Pre-application planning advice

Application ref: DC/23/4214/PREAPP

Homeleigh
The Common
Southwold
Suffolk
IP18 6HR

Pre-application advice is sought for the revised design of a first floor canopy over roof terrace. The applicant has been advised that works carried out to date are not appropriate within the Conservation Area.

**PART FIRST FLOOR PLAN AS PROPOSED
SHOWING THE EXTERNAL WALLS OF THE
SOUTH WEST AND SOUTH EAST
ELEVATIONS**

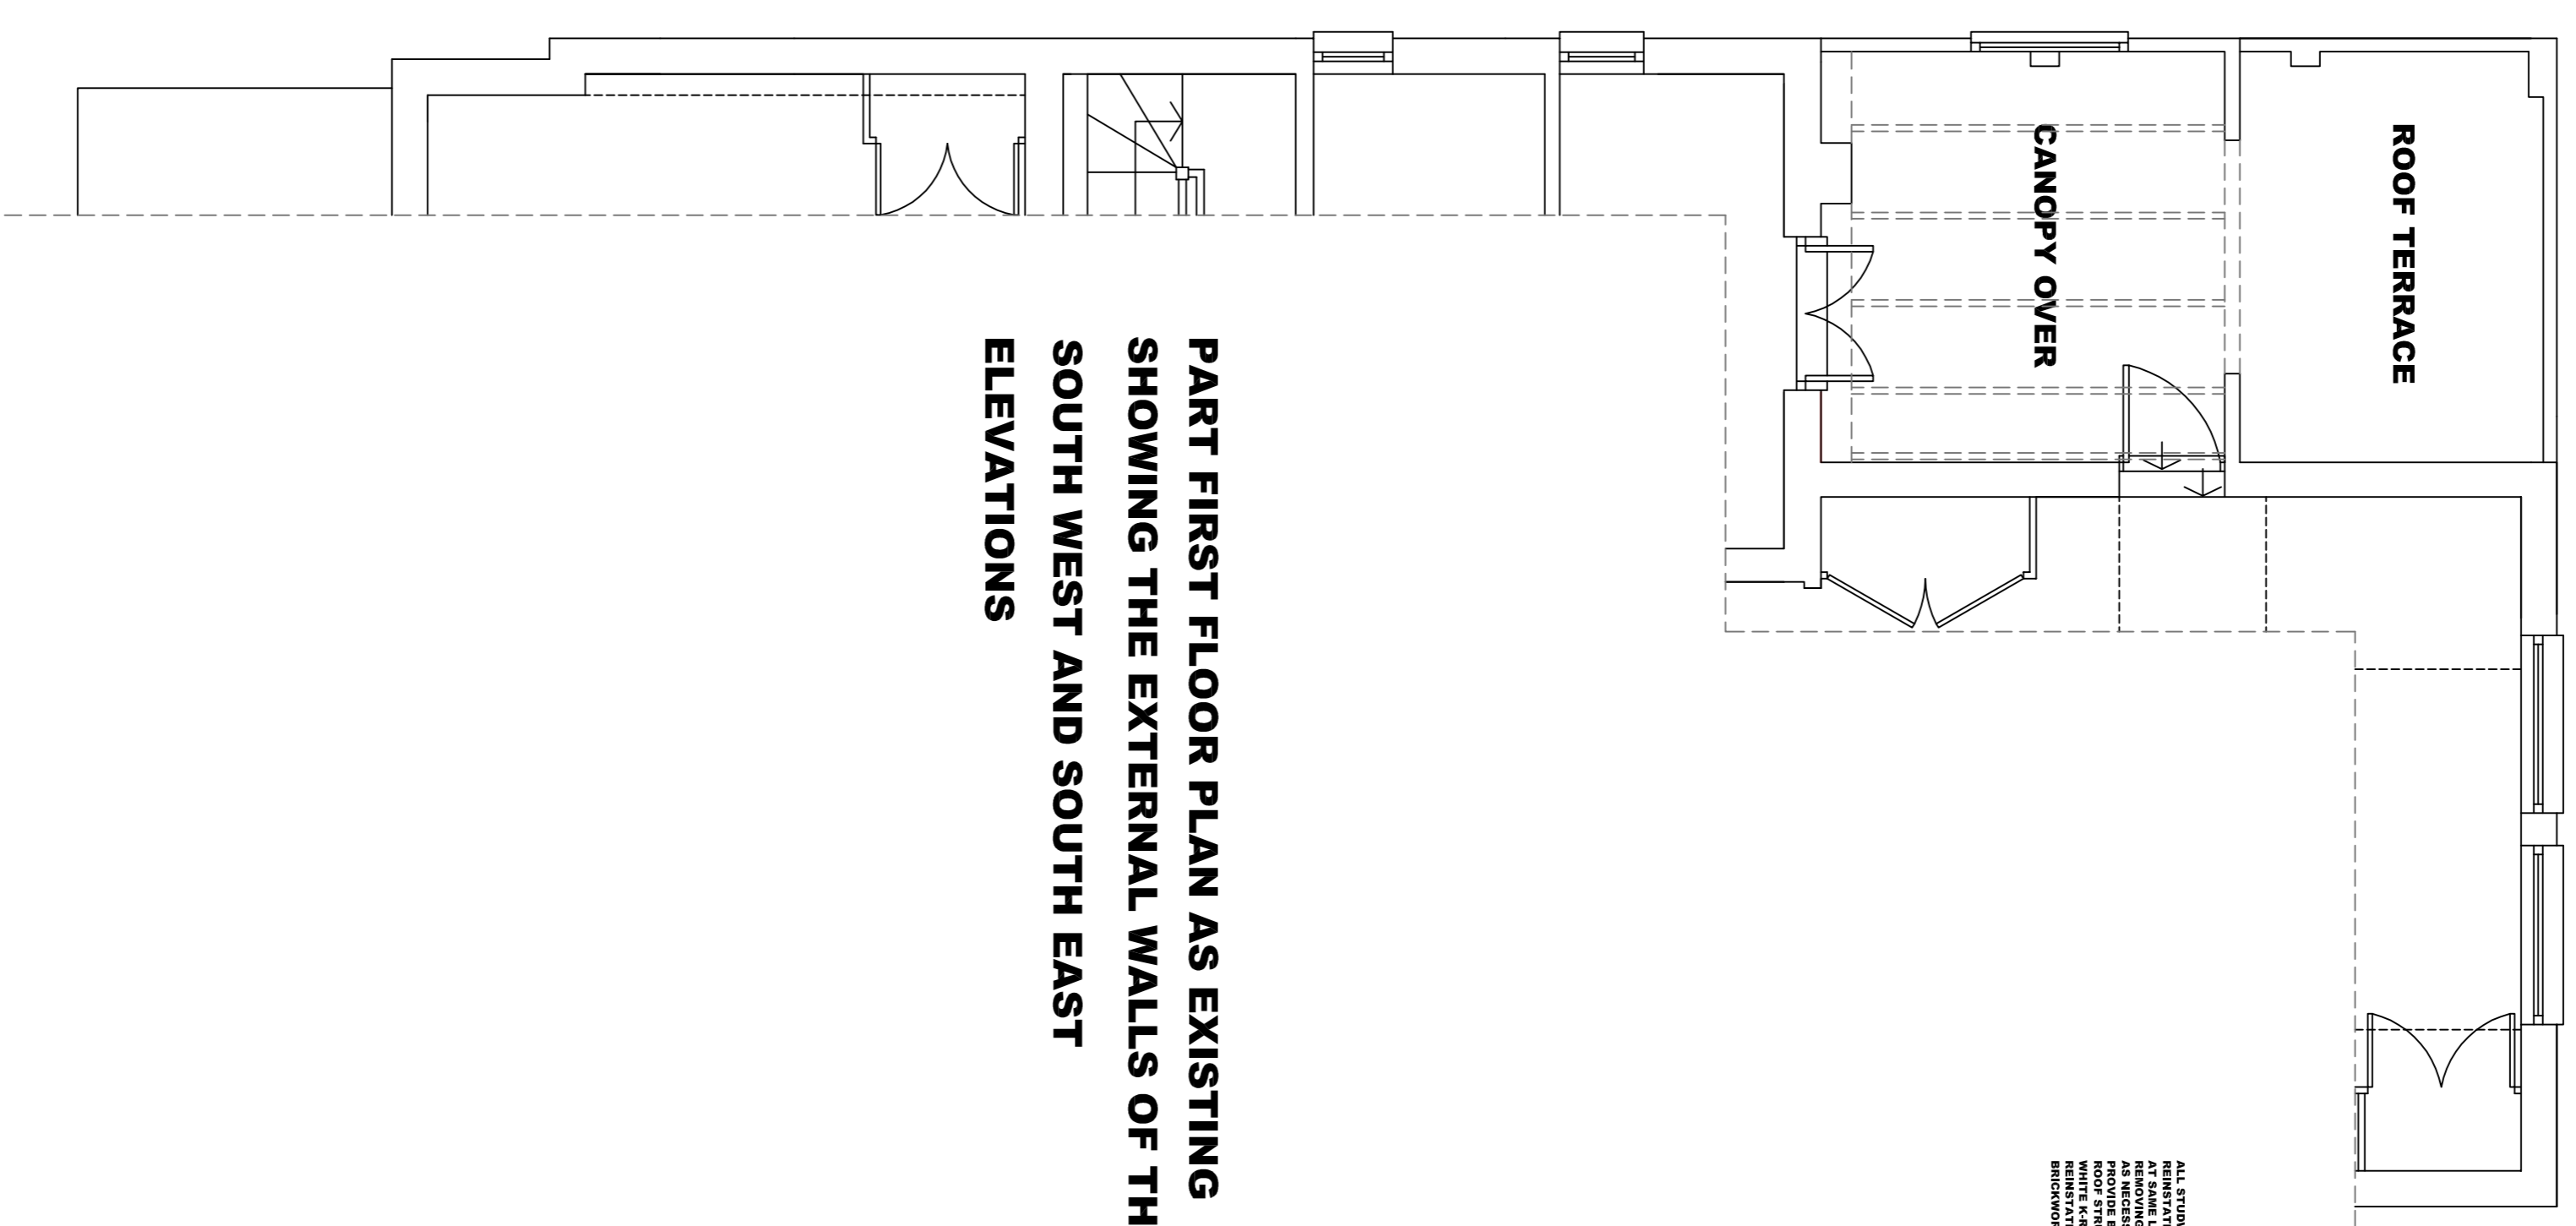
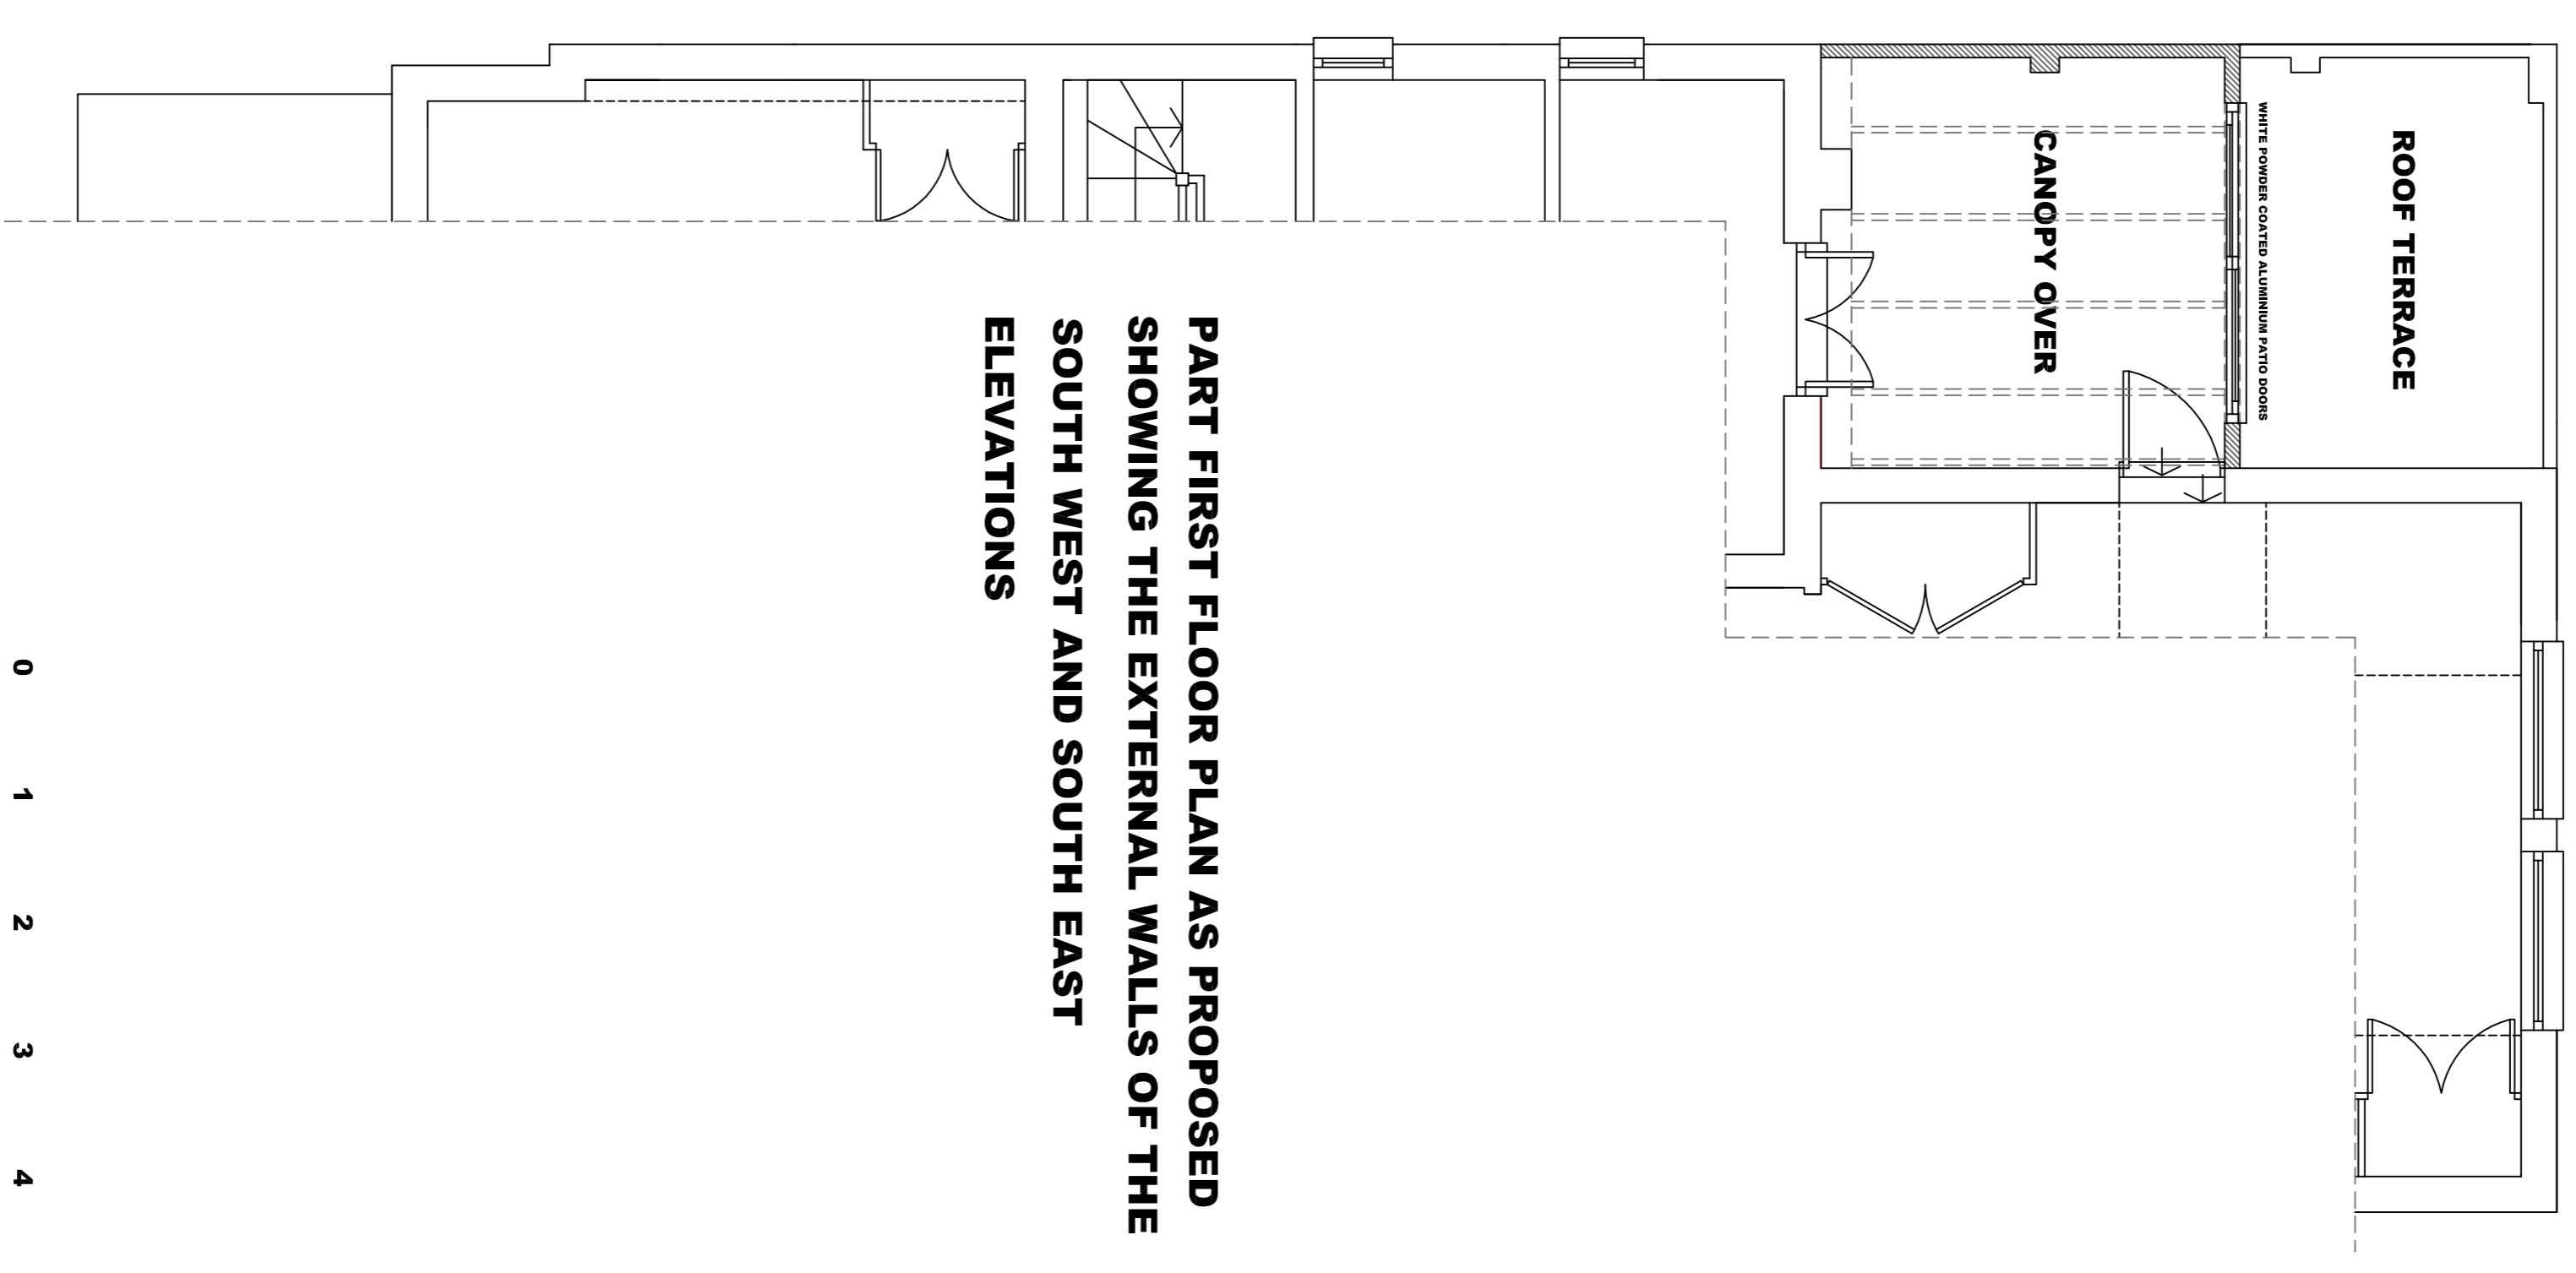
The proposed design would replace the upvc cladding with red brick to match the side wall of the property. This choice of material would be much more acceptable in the Conservation Area. It is not clear exactly what form and appearance the original terrace area had - it would be useful to have an idea of this if a formal application is made as we would assess the proposal against the lawful size/design/appearance of the property, not compared to any unauthorised works as existing.

The proposed drawings also refer to the use of k-rend however it is unclear exactly where this would be - presumably the front elevation. This would likely be acceptable as set behind the existing front wall of the terrace and therefore screened from public views. It is not clear what the original or proposed roof material would be. Assuming the previous structure was light-weight and the proposal is for similar, this is likely to be unobjectionable.

**ELEVATIONS AS EXISTING PRIOR TO RECENT WORKS TO FIRST FLOOR CONSERVATORY**

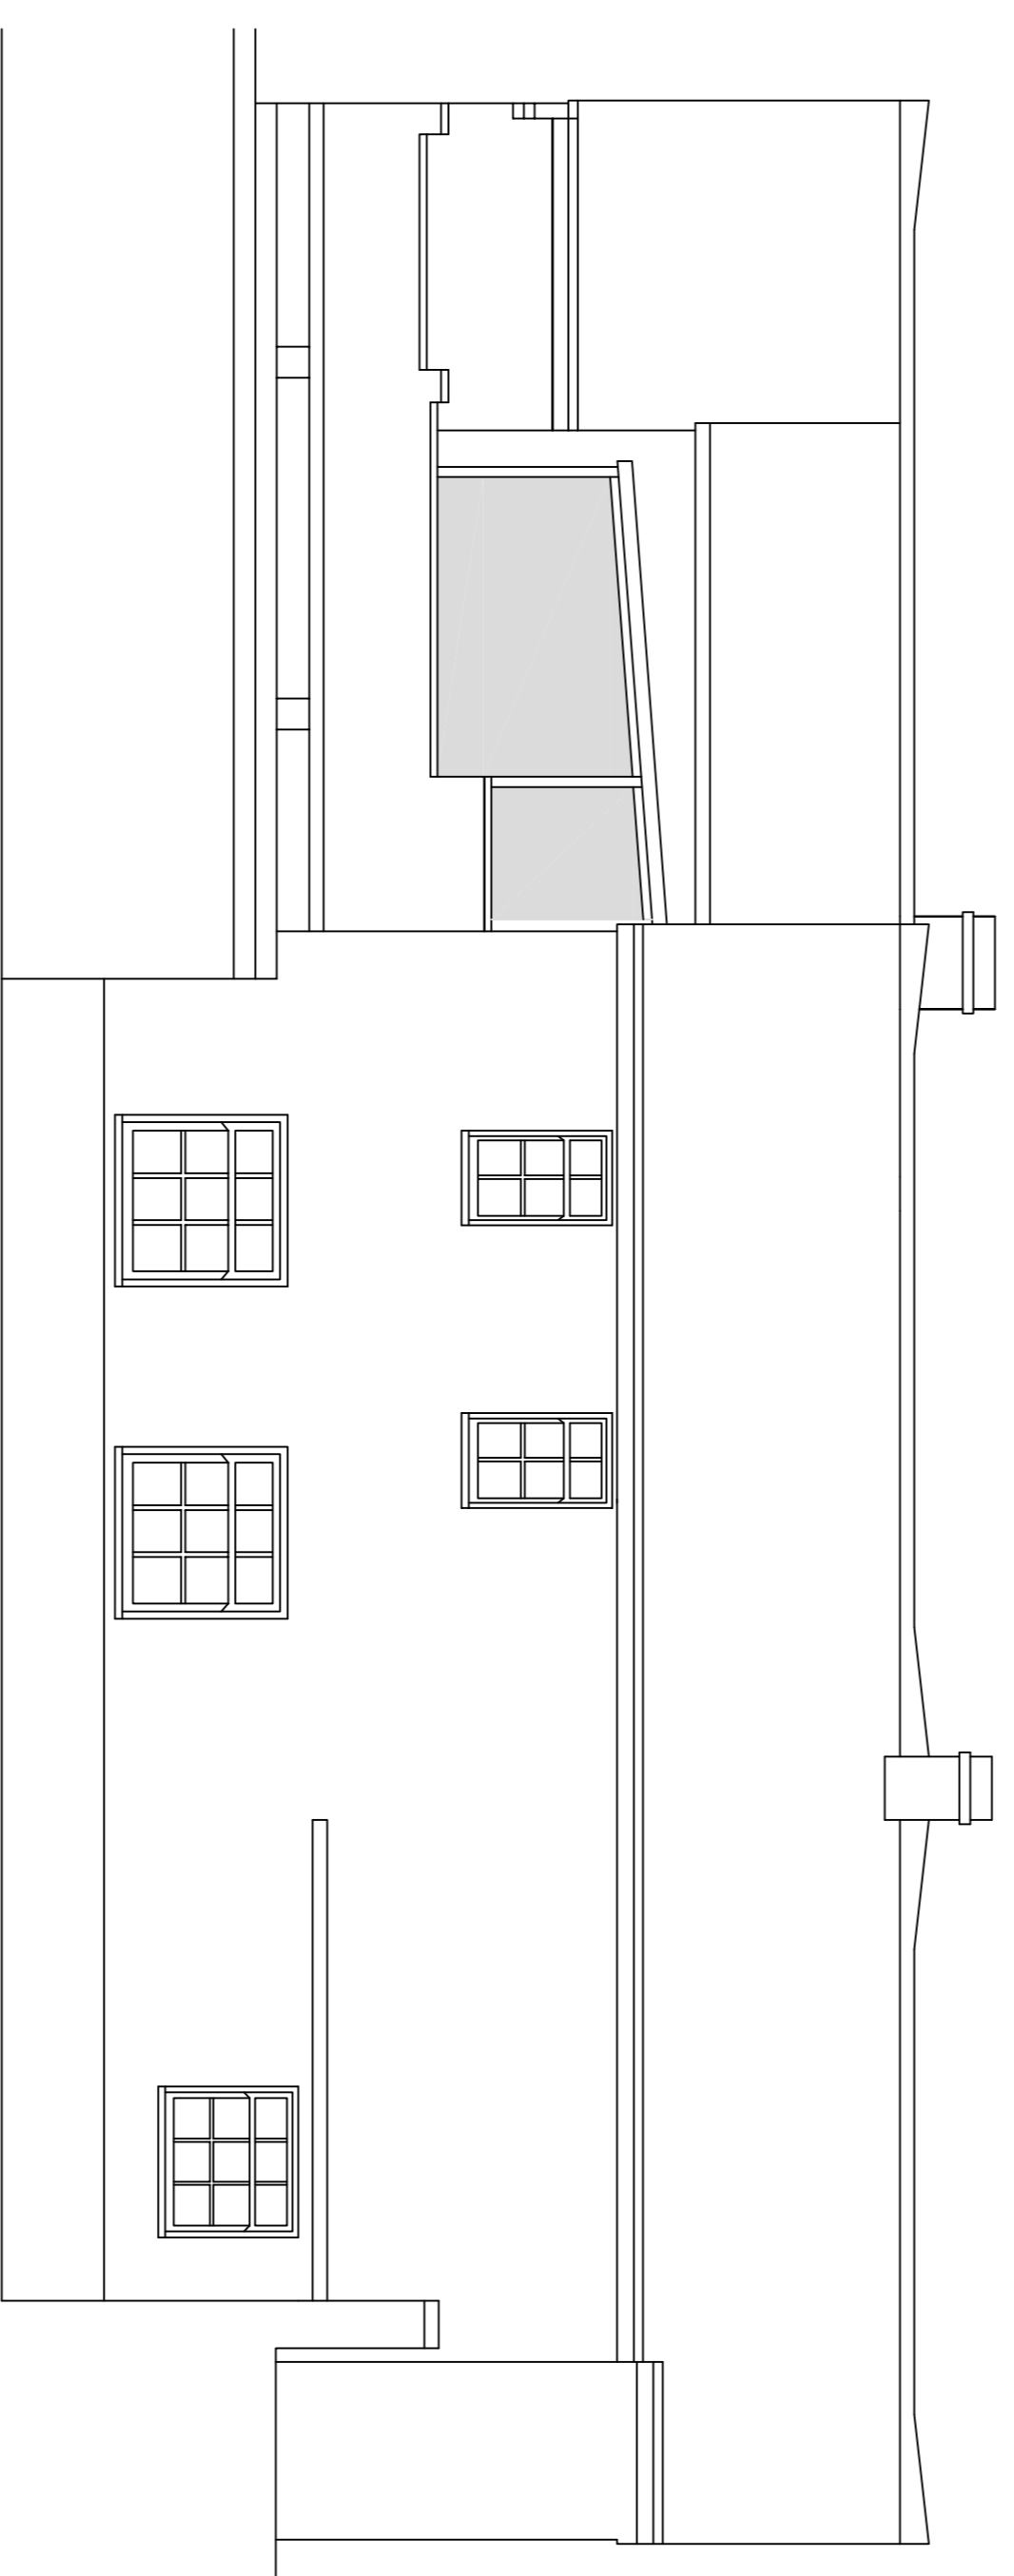
It also appears that the garage door below this area has been bricked up with a pedestrian door installed. It is not clear exactly when these works took place or exactly what works have been carried out. It is advised to include details of this in any future application for clarity.

The works as carried out are unlikely to be acceptable if an application were made for their retention; however the proposed drawings showing a similar sized structure of a similar form using red brick to match the existing side wall, and assuming a similar front elevation to that previously on the property, the revised scheme is likely to be supported by officers. It will, however, be important to undertake a site visit to fully consider the potential impacts as part of any formal application. If a formal application is made, we will need details of the original structure that was there, not just of the existing in its unauthorised form.
